**Project: Vickery Mine Extension Project**  
**Stage: Review Draft Conditions of Approval**  
**Development Application: SSD-7840**

I refer to the email dated 22 January 2020 inviting the Resources Regulator to provide advice on the Draft Conditions of Approval for Project Vickery Extension Project.

11 March 2020

Figure 8: Conceptual Rehabilitation Plan

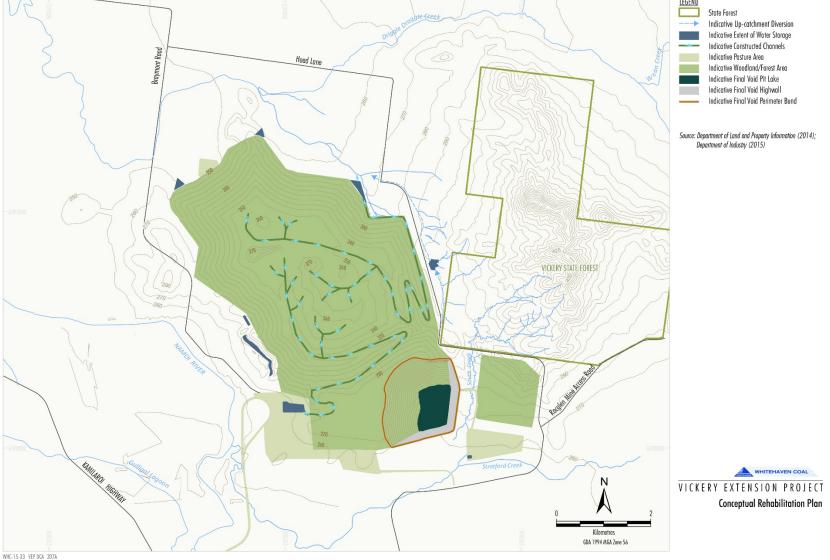
B100. The Applicant must rehabilitate the site ~~to the satisfaction of the Resources Regulator~~ in accordance with the conditions imposed on the mining lease(s) associated with the project under the *Mining Act 1992*. The rehabilitation must be generally consistent with the proposed rehabilitation ~~activities~~ **objectives** described in the documents listed in condition A2(c) (and

shown conceptually in the figure in Appendix 6), and must comply with the objectives in Table 13.
